15/11/2019

Tweed Valley Hospital Stage 2 (SSD-10353)
Response to Submissions

#### FACADE TYPE PLANS MHB - BASEMENT

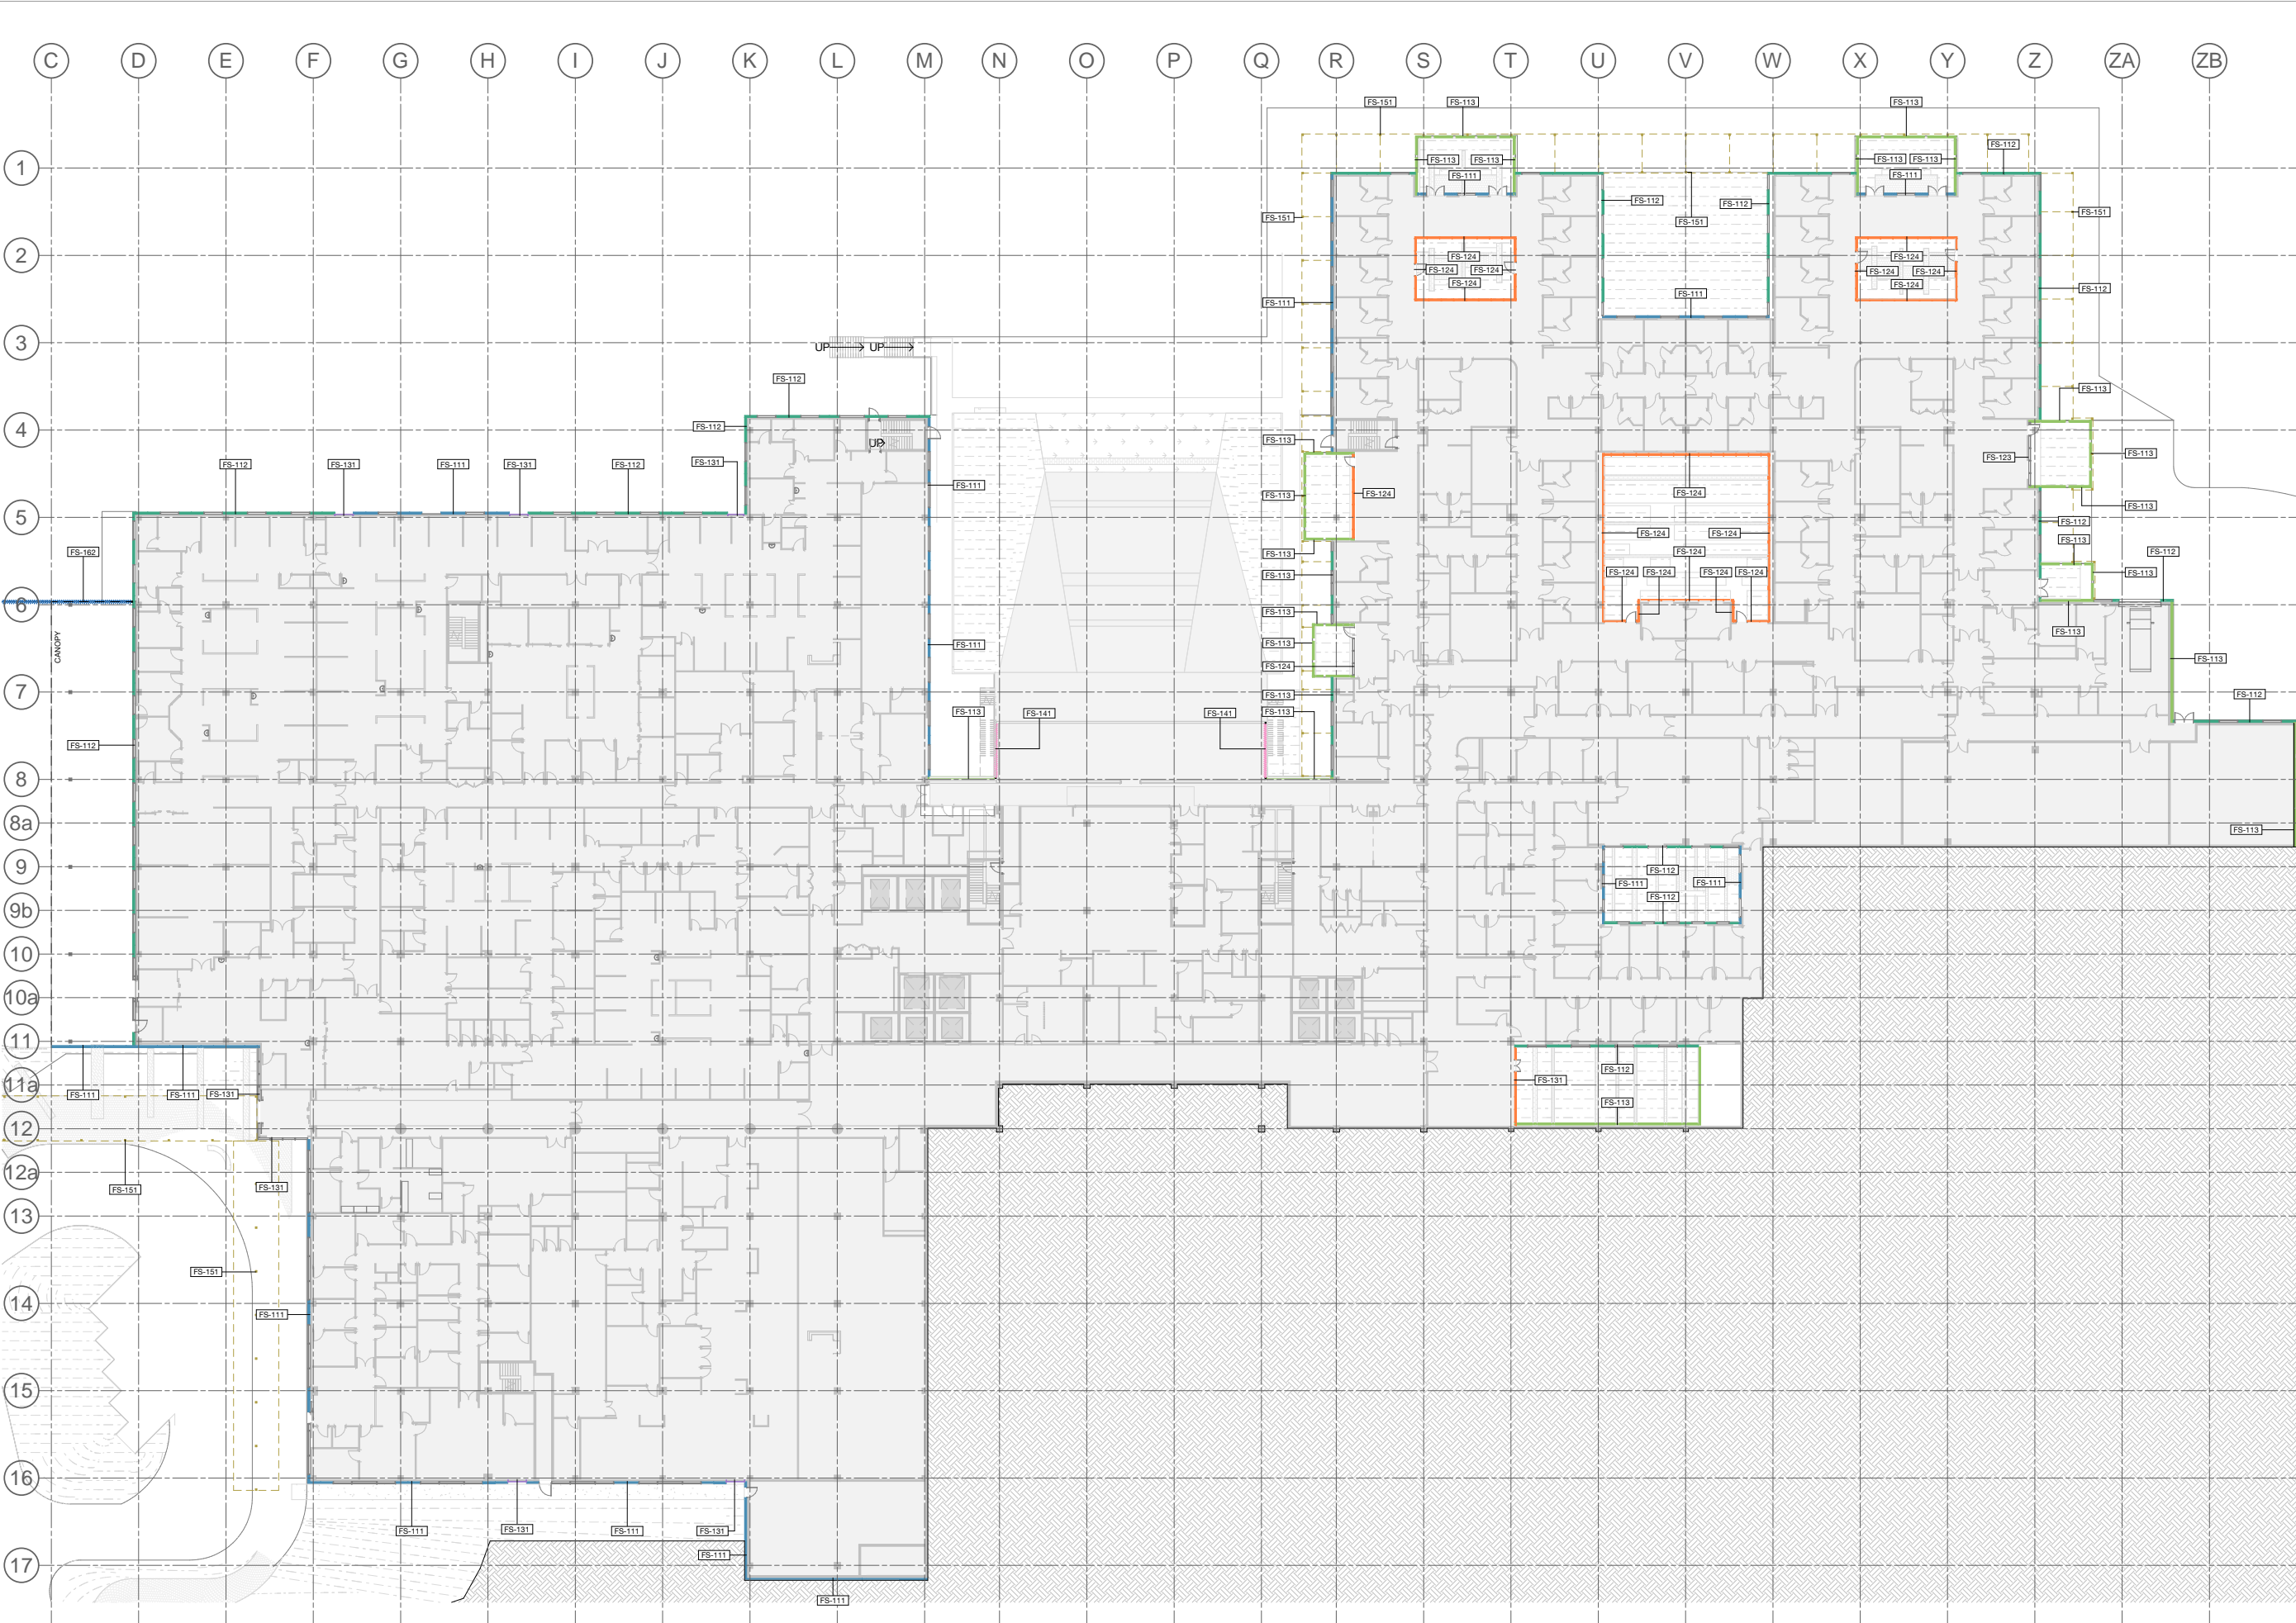
- absence of courtyard at the Basement Level.
 - absence of an internal courtyard on the north-western side of the Lower Ground Floor.
 - absence of light voids on the Ground Level and Level 1.

**FACADE TYPE PLANS  
MHB - LOWER GROUND**

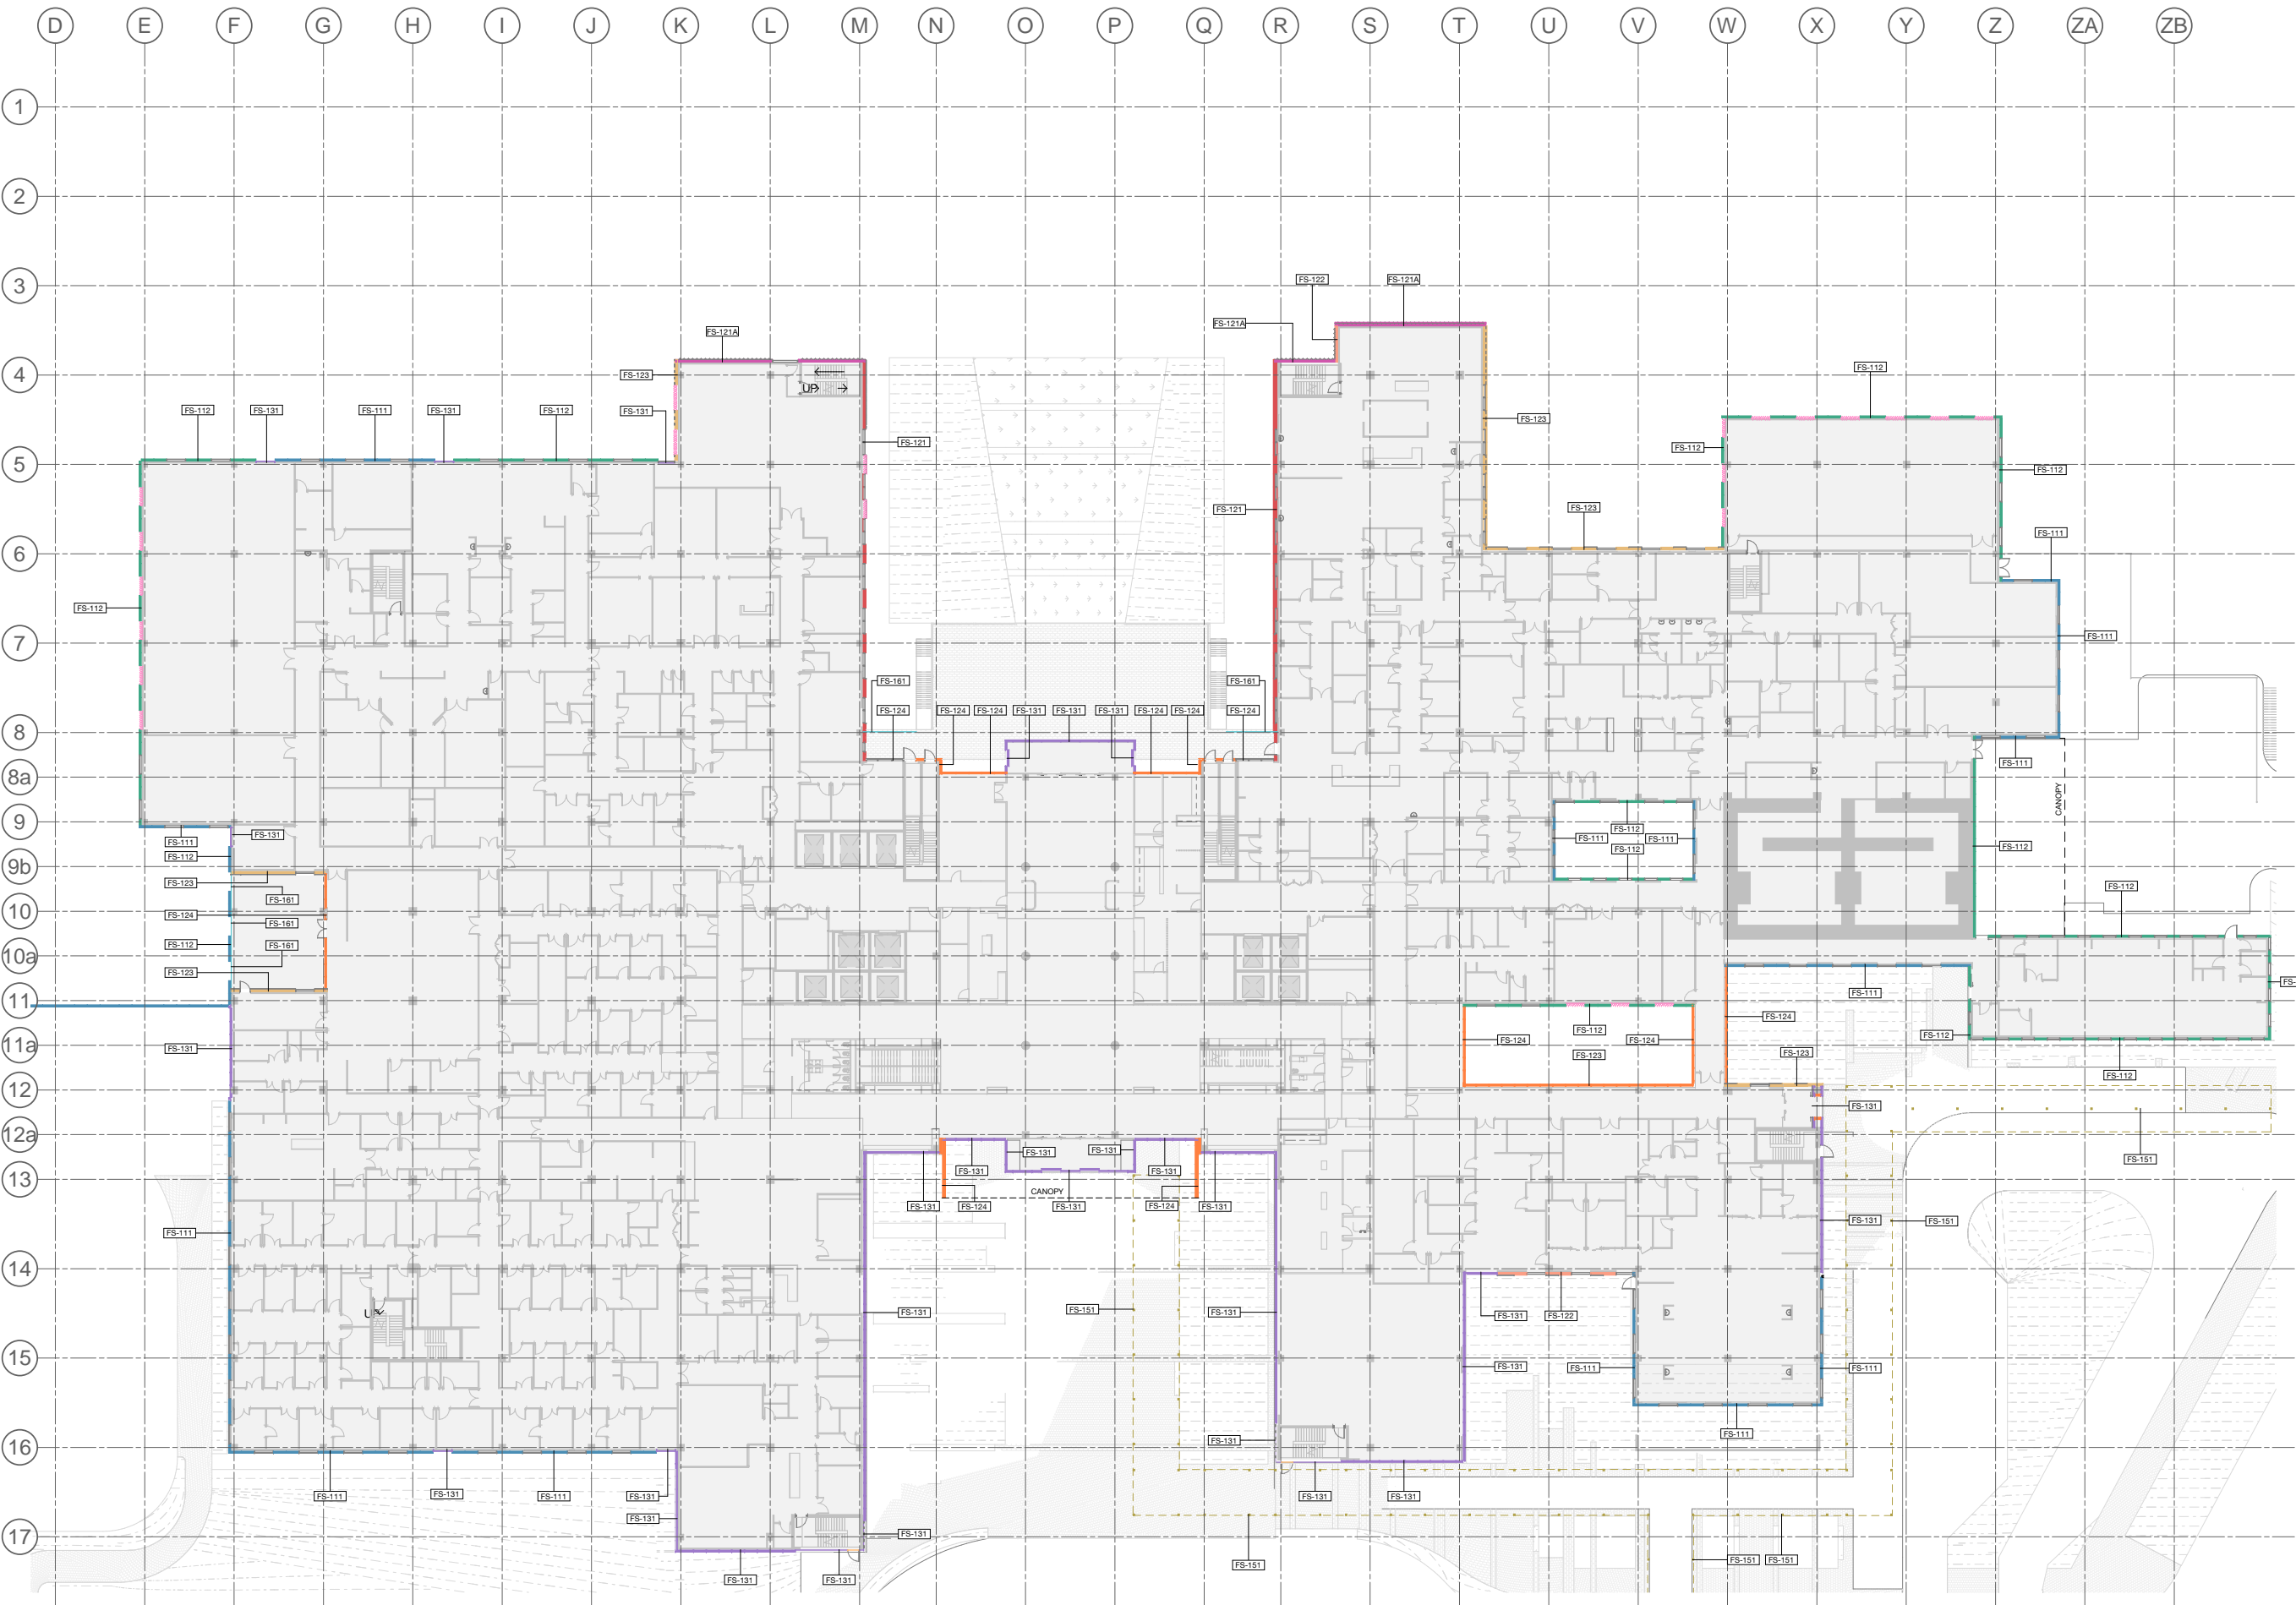
- overly long and narrow corridors on the Lower Ground Floor and Ground Floor with no provisions for natural light.
 - inadequate size of the internal courtyard on the north-eastern side of the Lower Ground Floor.

MHB - LEVEL 02

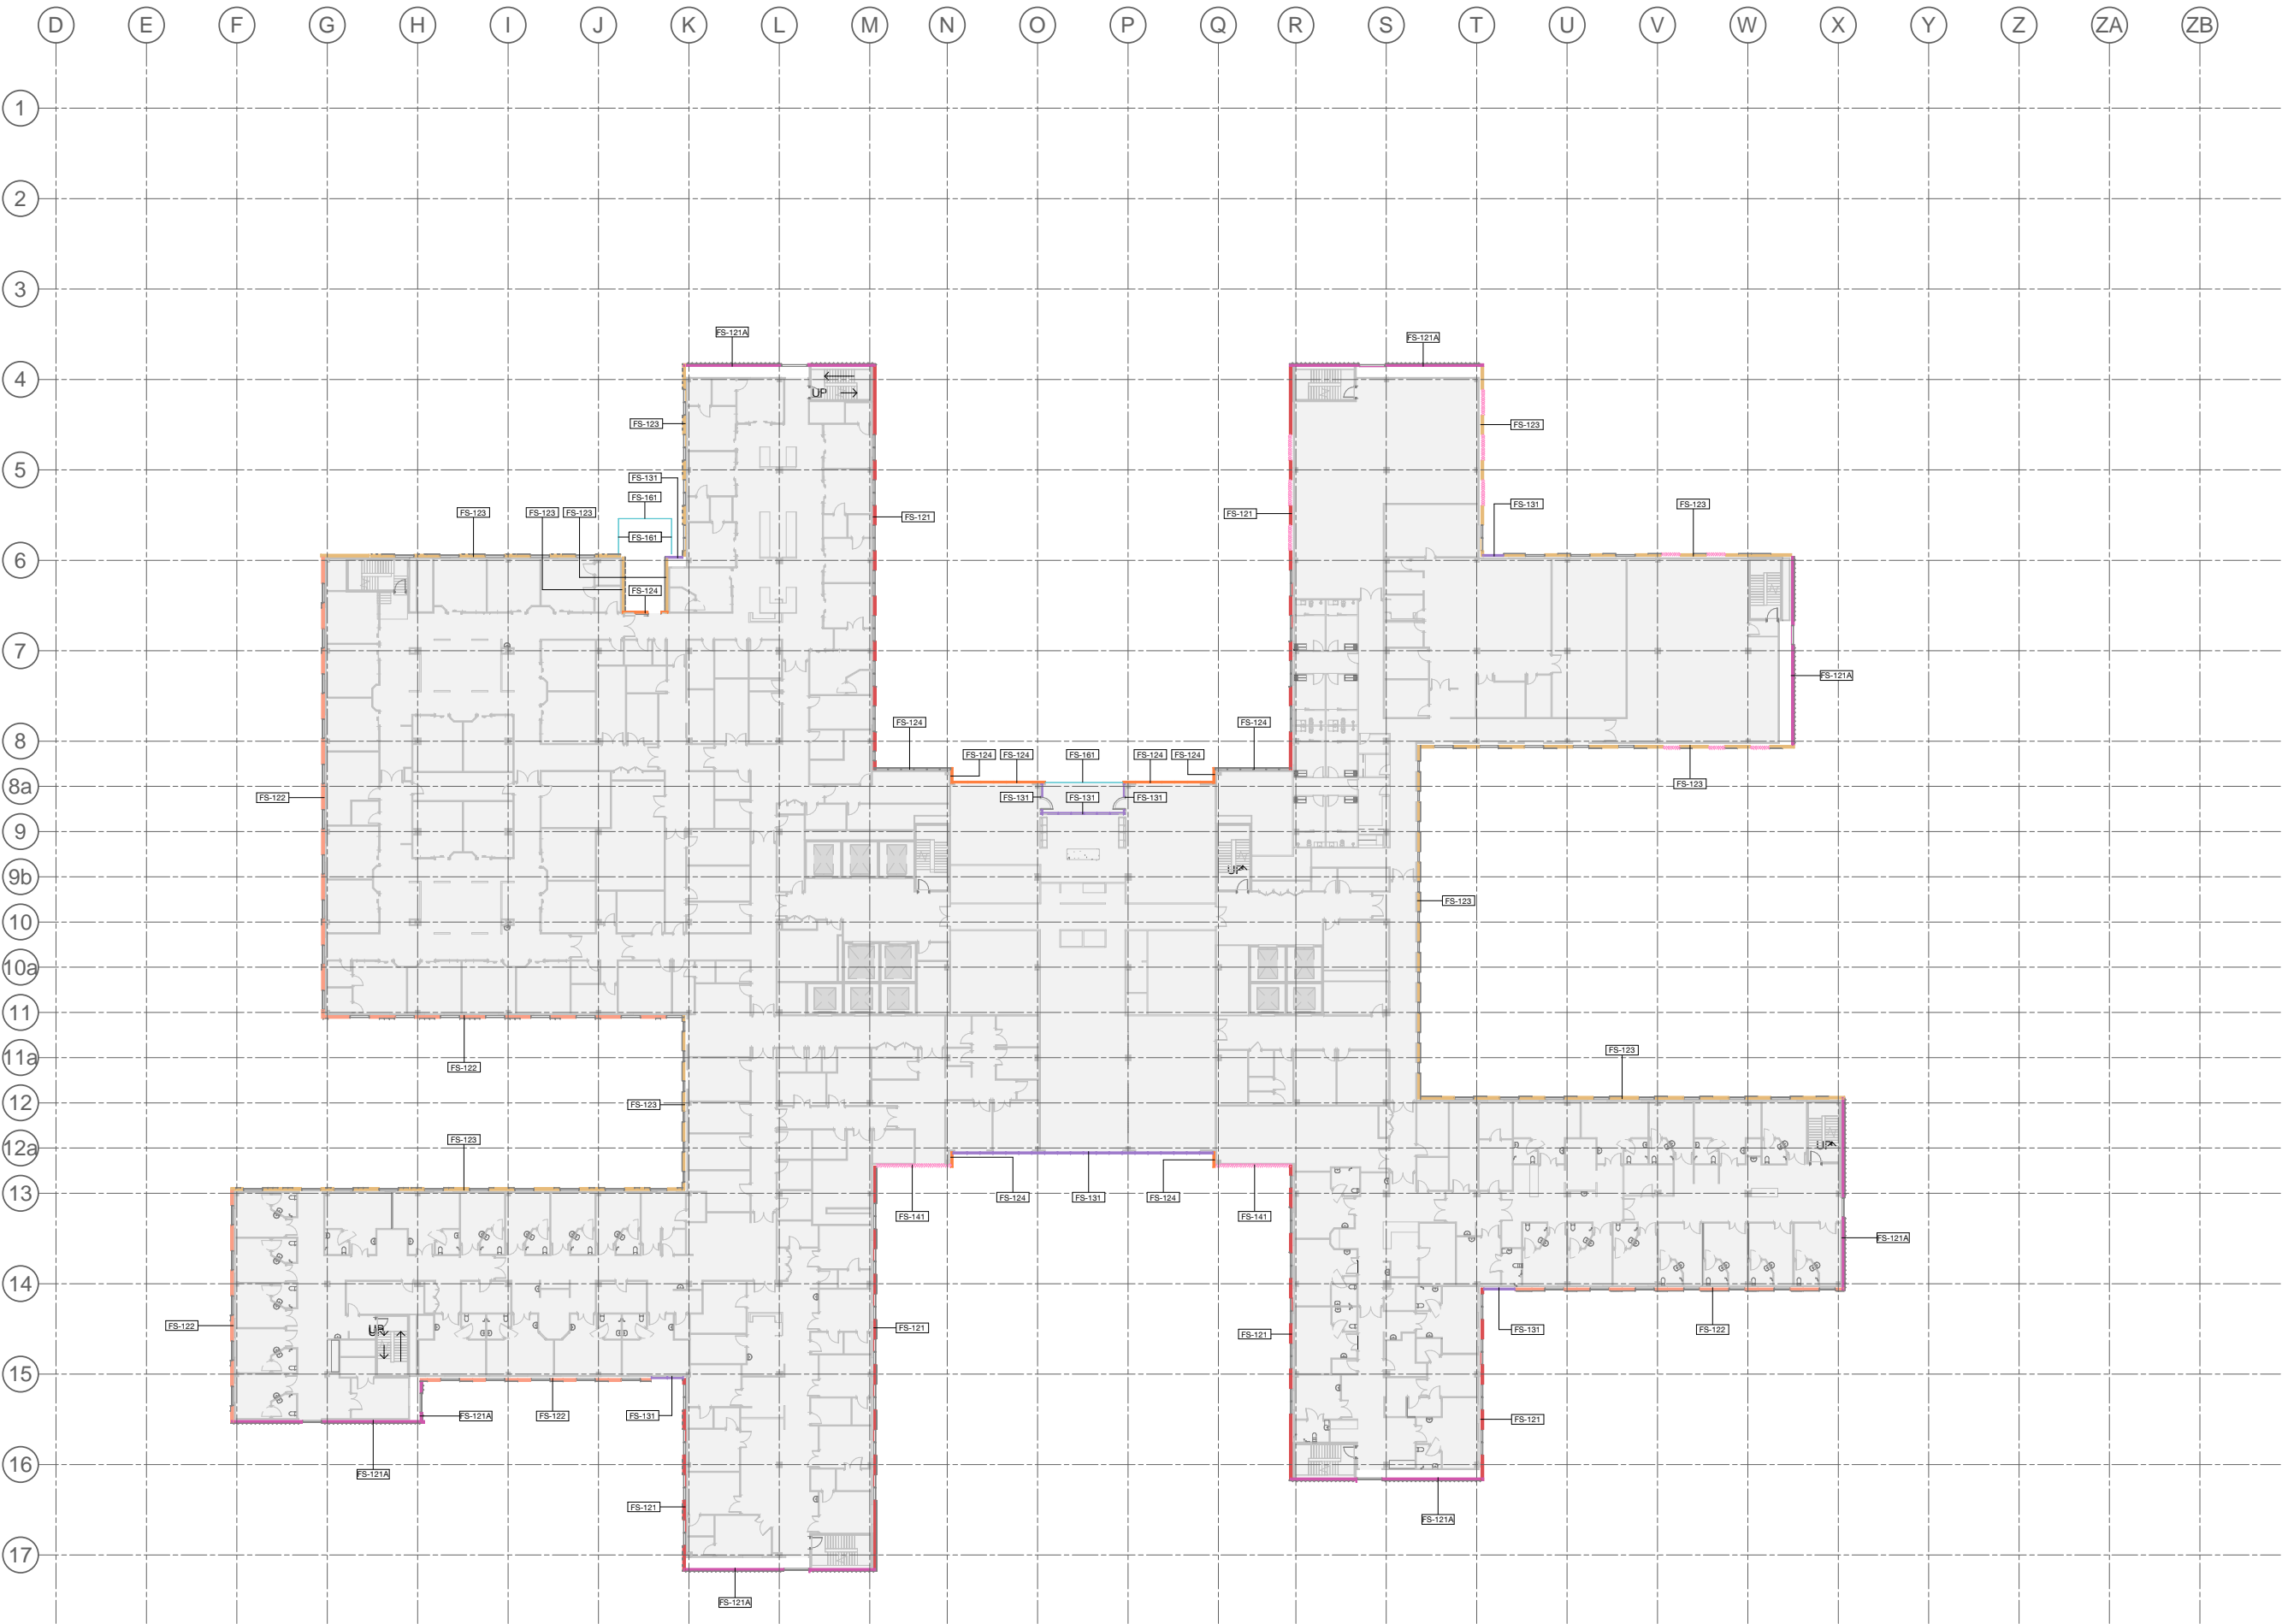
- sky gardens to the north-west / north-east of the shared administration area on Level 2.
 - increase in the size of the Level 2 sky gardens catering for the ‘Child & Adolescent’ and ‘Older Persons’ in-patient units (a minimum of 50% increase above the proposed size).
